Project:
**Land North of Pendle Road
Clitheroe**

Project No:
T25604
Report Title:
Transport Assessment Addendum

Prepared by:	DB
Authorised by:	JP
Rev:	-
Date:	06/04/2026

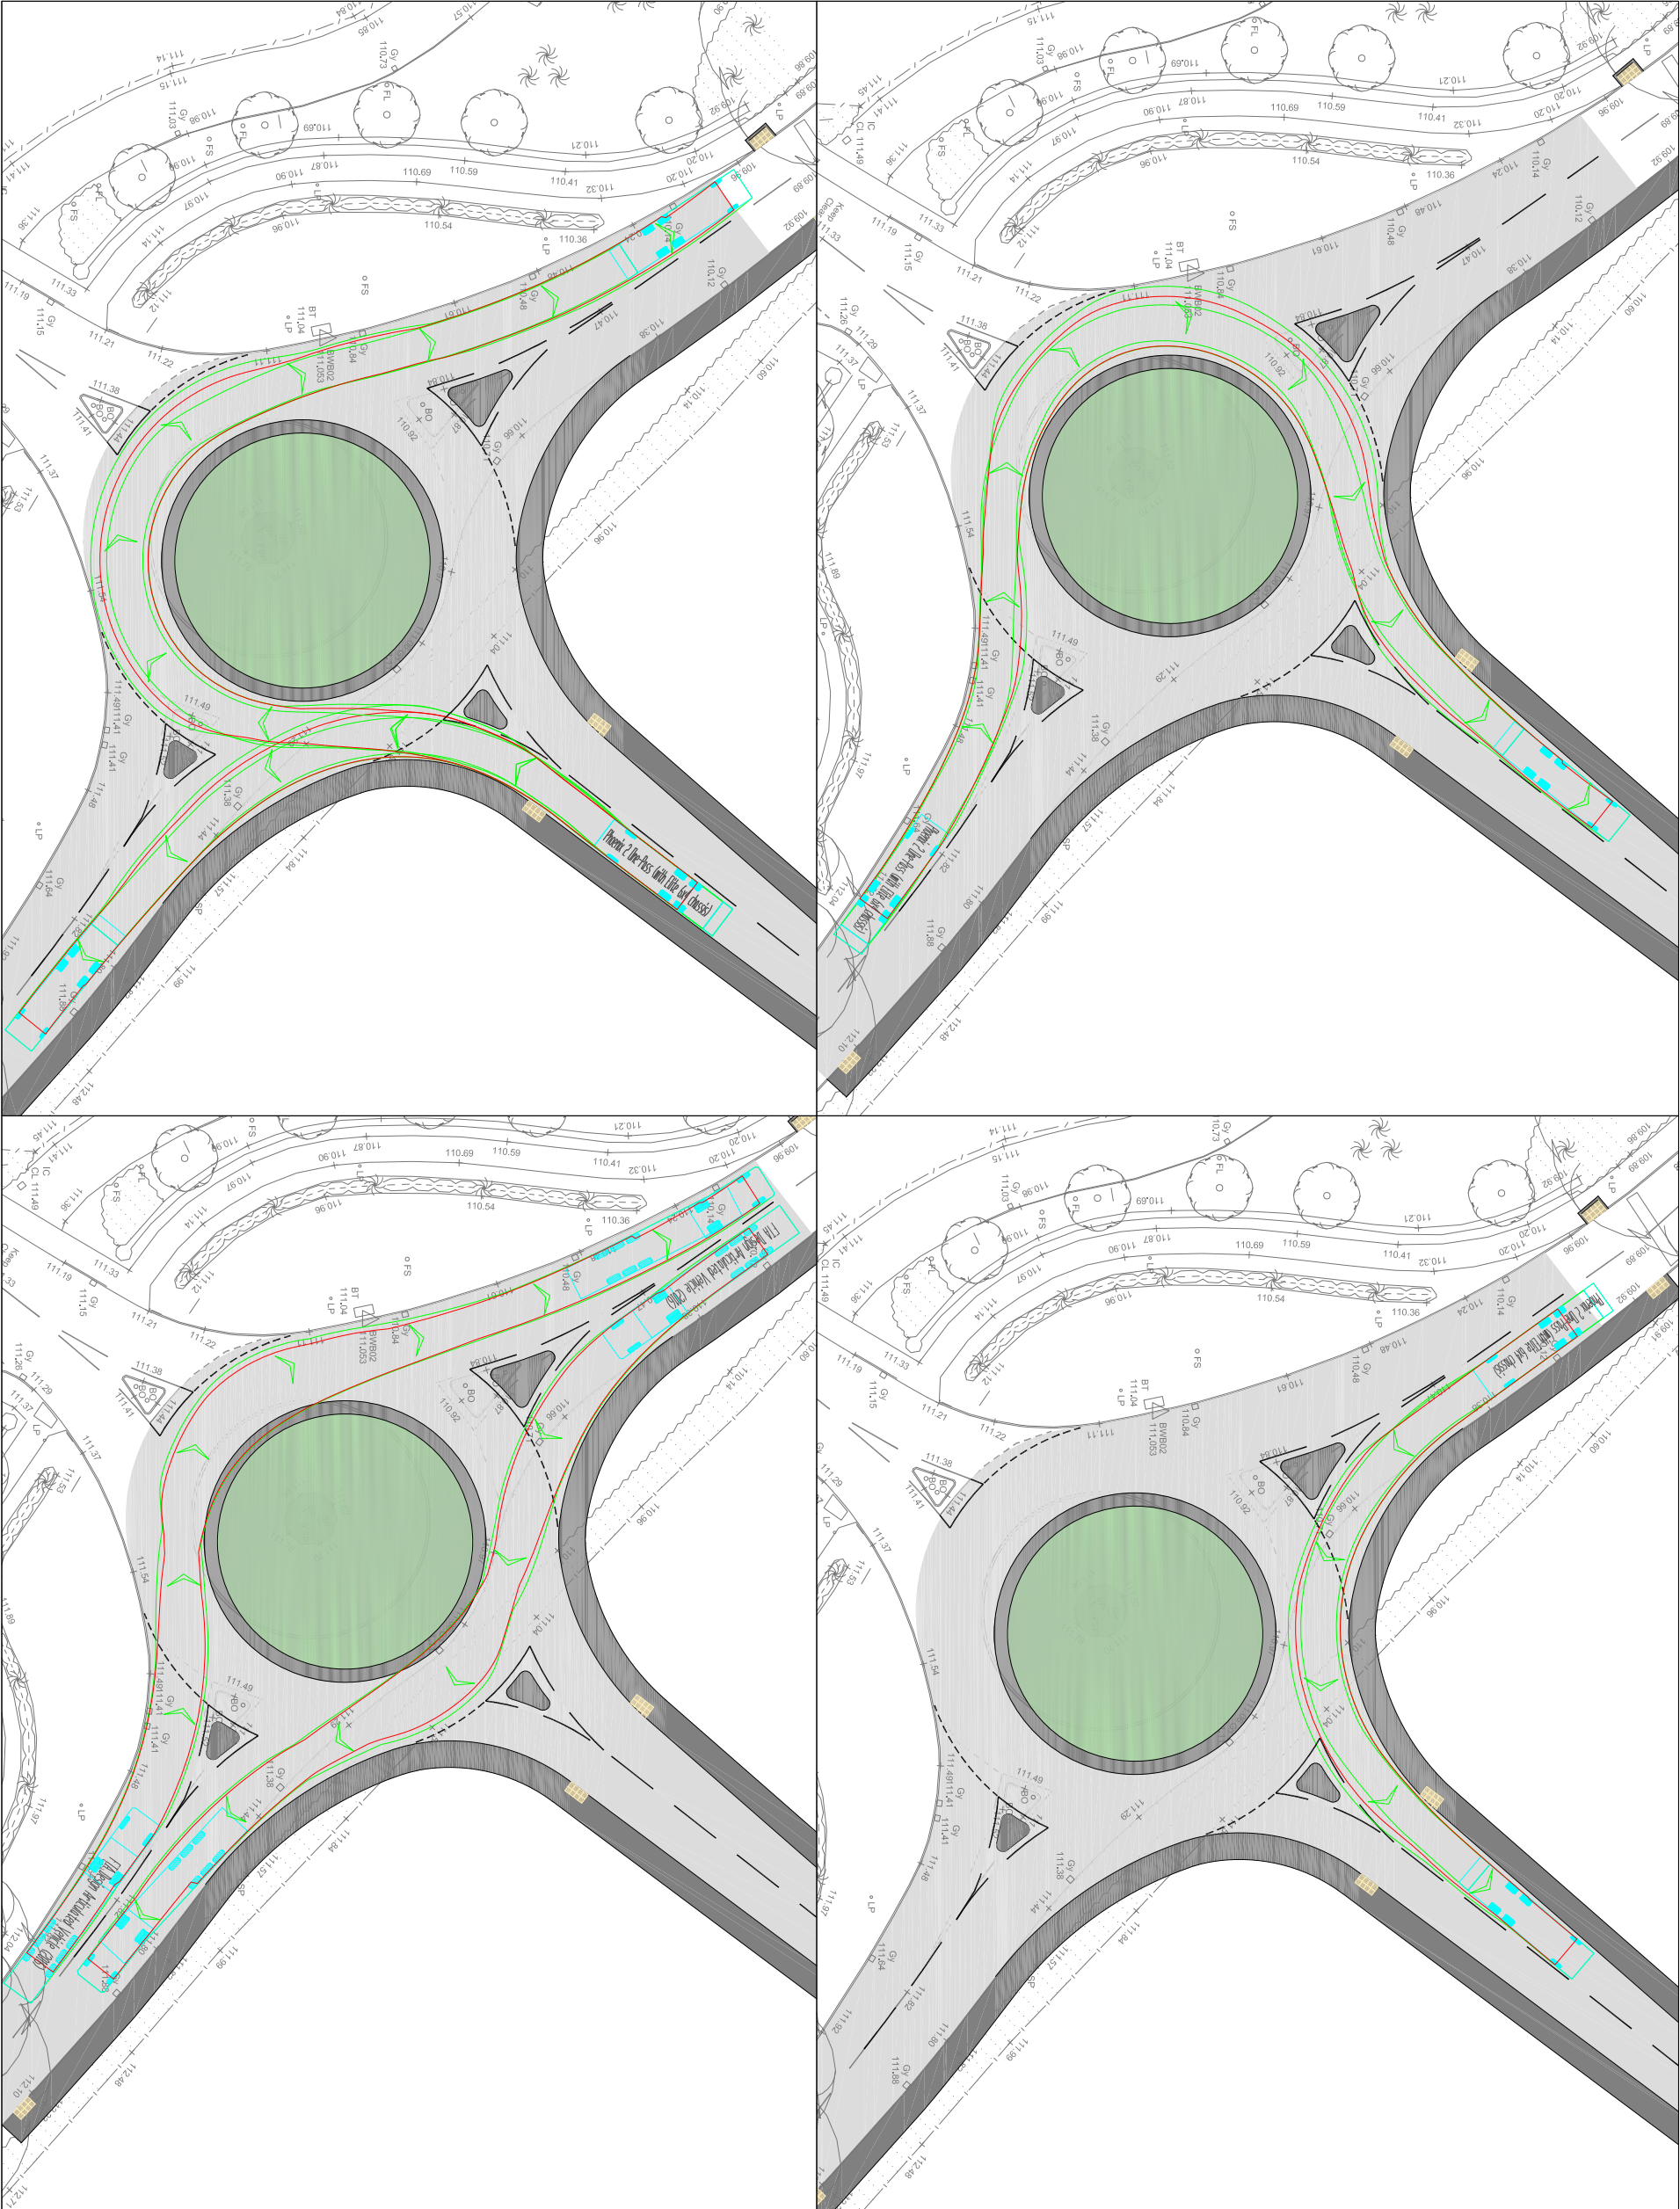
- The LHA has requests that a DMRB CD 116 checklist is provided for the site access roundabout, highlighting any departures from standard. Additionally, consideration should be given to shared cycle/footway at the junction and whether pedestrian/cycle crossing infrastructure could be included across the central islands of the roundabout.

Pendle Road C553 is subject to a 40mph speed limit. A new 4th arm will be created on the roundabout at Pendle Road/Higher Standen Drive with an increase of ICD to 32m providing a compact roundabout to DMRB CD116. A checklist is requested to CD116 with departures and relaxations highlighted.

We would request that the new footway to the northwest and southeast sides of the roundabout should be widened to 3.5m to provide a shared cycle/footway.

- 3.14 **Drawing T25604.001 rev A** shows 3.5m wide shared pedestrian and cycle provision around the northeast and northwest sides of the roundabout, as requested by the LHA.
- 3.15 In addition, the eastern side of the junction now provides pedestrian crossing provision through the central splitter island; it isn't feasible to provide cycle crossing provision, on the basis that the available adopted highway extent on the southern side of the junction is c.2.0m in width. However, cycle access is provided from the southeast corner of the site and from the western end of the site to the route through to Centurion Way, using the parallel crossing (as requested by the LHA).
- 3.16 The updated swept path drawing is shown on **Drawing T25604.002 rev A**.
